CITY OF ALBUQUERQUE
MUNICIPAL DEVELOPMENT DEPARTMENT
ENGINEERING DIVISION

CONFERENCE RECAP

SUBJECT: S.W. CORNER OF 1st St. & E. Ave. (150' W x 150')

Re: Blake's Lota Burger, Juan Tebo & Lexington, Dated 11/15/82
(File No. H21-D12)

SITE PLAN
JUAN TABO & SNOW HEIGHTS

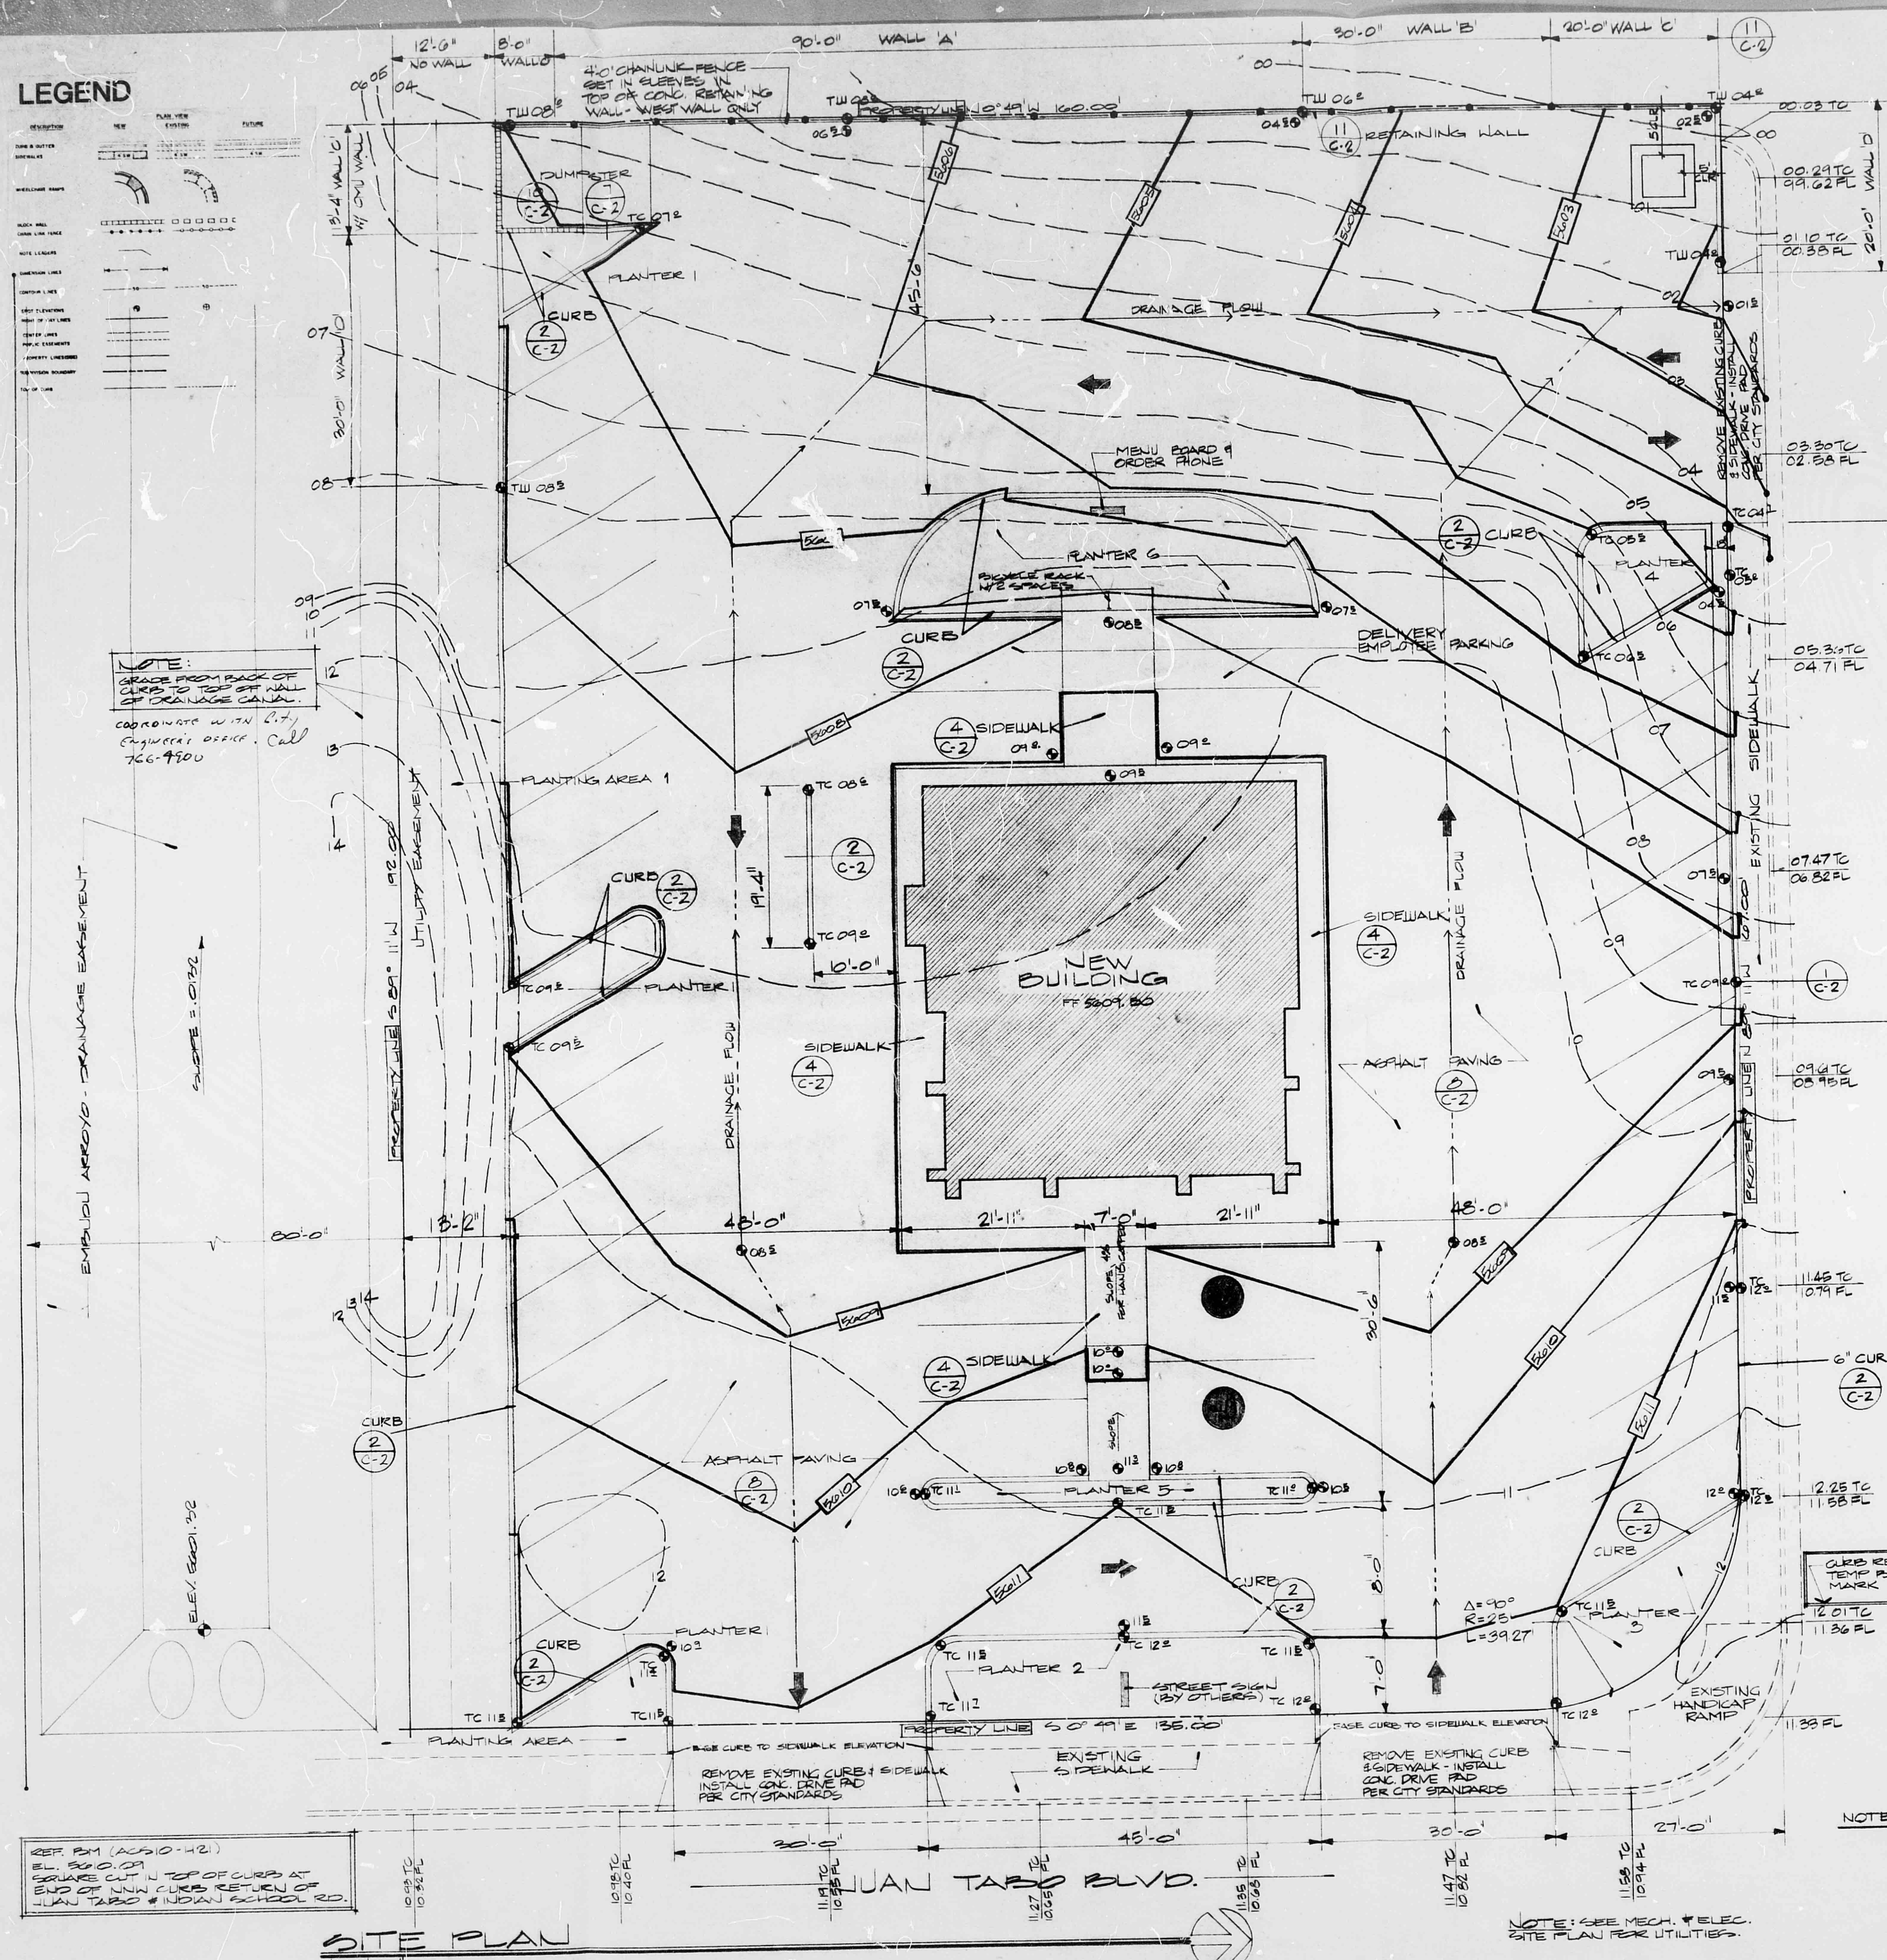
Attached are my comments (in red) for the referenced project. Please include the information requested in your resubmittal.

Since the arroyo immediately adjacent to the site is presently being improved (that is lined) and there is a flooding problem downstream, this office requests that you explore the possibility of discharging directly into the arroyo. Please investigate the aforementioned and let us discuss your findings.

As you asked in your transmittal letter and we discussed with you on the telephone, we have investigated the possibility of discharging directly into the concrete lined arroyo adjacent to the south boundary of the site and have the following information to submit:

- 1) The traffic requirement of our client to have an entry/exit onto Snow Heights Boulevard at the northwest corner of the site precludes any chance of draining the entire site to the south and into the arroyo. We investigated the possibility of reversing the surface flow or directing a portion of the surface flow into the arroyo. In both instances, we encountered slopes that were not acceptable to the movement of traffic.

- 2) The only other possibility would appear to be to install a storm water collection box at the northwest corner of the site. The top would be at elevation 5601; FL. at elevation 5998; and the discharge elevation into the arroyo would be at elevation 5996 (approximate). The flow line of the existing concrete lined arroyo at a point opposite the rear lot line is elevation 5595.0. The pipe would discharge into the arroyo during flood stage under water. Depending on the depth of water in the arroyo (the sides are extended some eight (8) feet above the flow line), the hydraulic gradient, etc., it would be possible to not only restrict the flow, but to reverse it in the storm water collection box. The cost-effectiveness of such a solution is negative as it would be difficult to recommend such an expensive system in return for a non-positive storm drainage answer.

3) We further investigated the area you have designated as a "flooding problem downstream." The slopes and grades on Snow Heights Boulevard are more than adequate all the way down to the junction with the branch arroyo that drains back into the Embudo. The problem appears to be the manner in which the storm water is channeled into the arroyo and the change in the street cross-section. The present conditions will pond water at the branch arroyo until they are revised, regardless of the quantity of storm discharge.

In view of the preceding information, I would recommend that Blake's LotaBurger be permitted to discharge onto Snow Heights Boulevard, and that the City rework the problem area as discussed.
